Report of the meeting of the Development Control Post-Committee Site
Inspection Panel held on 03-MAR-2015

REF NO: **AW/312/14/HH**

LOCATION: 37 Kingsway
 Bognor Regis

PROPOSAL: Single storey side & rear extensions & carport (resubmission following
 AW/132/14/HH). This application affects the character and appearance of the
 Craigweil House Conservation Area.

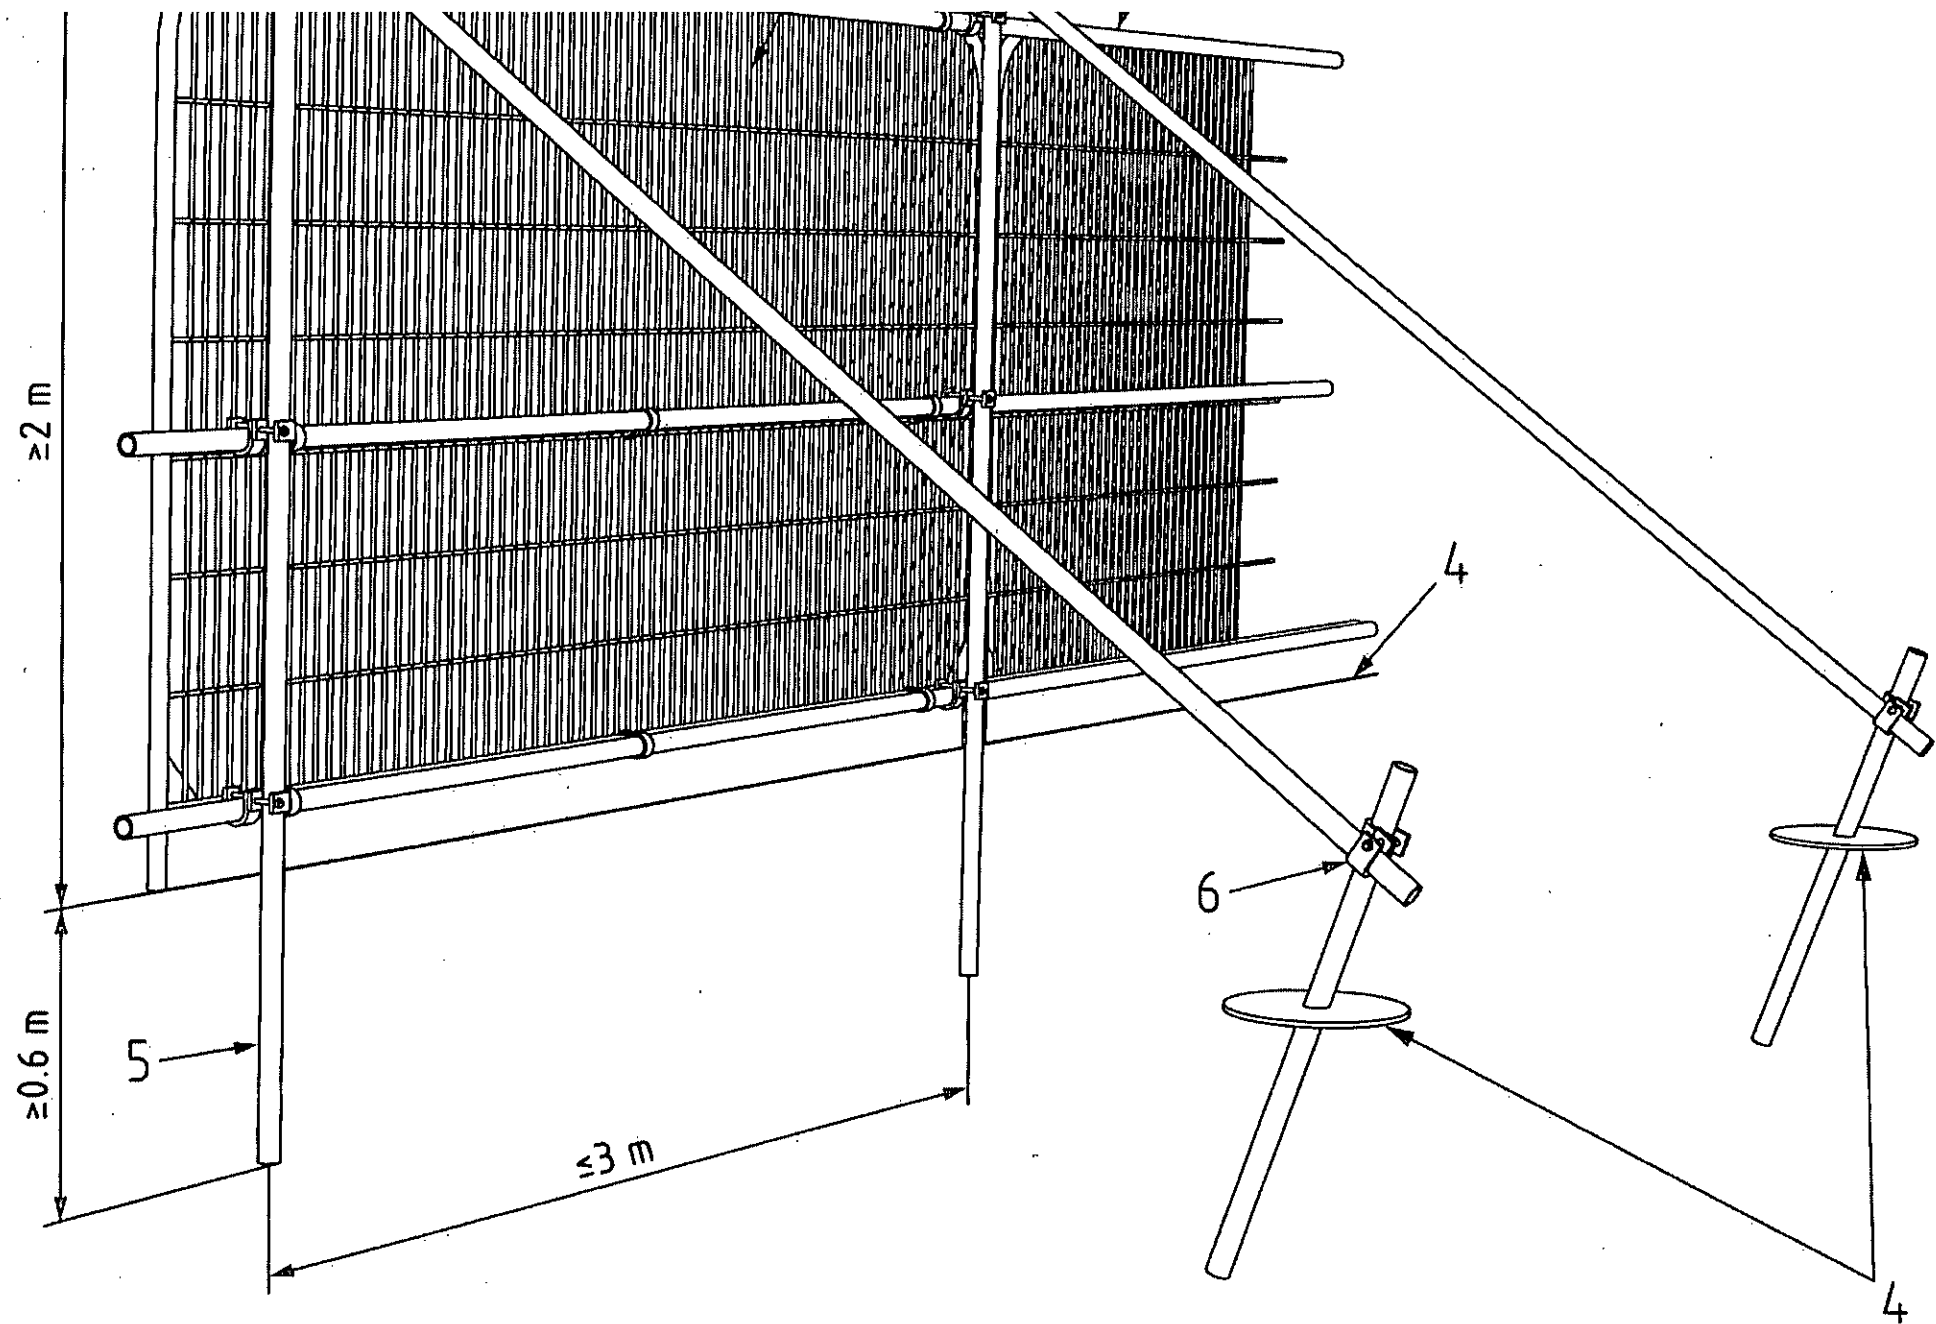
The submitted application has failed to address or acknowledge any potential conflict with this development and any surrounding trees. It is apparent that this development could interfere with T1 and T2, as both trees are standing within 1 meter of the boundary to No 37, and the proposed development appears to be requesting to construct up to the boundary line between 37/39.

As stated previously, the calculated Dbh of T1 would be 27.5 m², which equates to circle with a radius of 2.9 meters. From the submitted plans, it does appear the proposed development will include excavating/construction within the RPA of T1.

As stated previously, the calculated Dbh of T2 would be 15.5 m², which equates to circle with a radius of 2.2 meters. From the submitted plans, it does appear the proposed development will include excavating/construction within the RPA of T2.

The submitted application has failed to meet the criteria set by the BS 5837:2012 - Trees in relation to construction. The application, if approved, should be subject to a condition as per BS 5837:2012 for this proposed operation.

To meet the BS 5837:2012 standard, the applicant must use of static fencing, which must be erected before the construction process begins, and must be left unadulterated until the project has finished. An attached diagram illustrates the standard of fencing that is required to meet the BS 5837:2012.
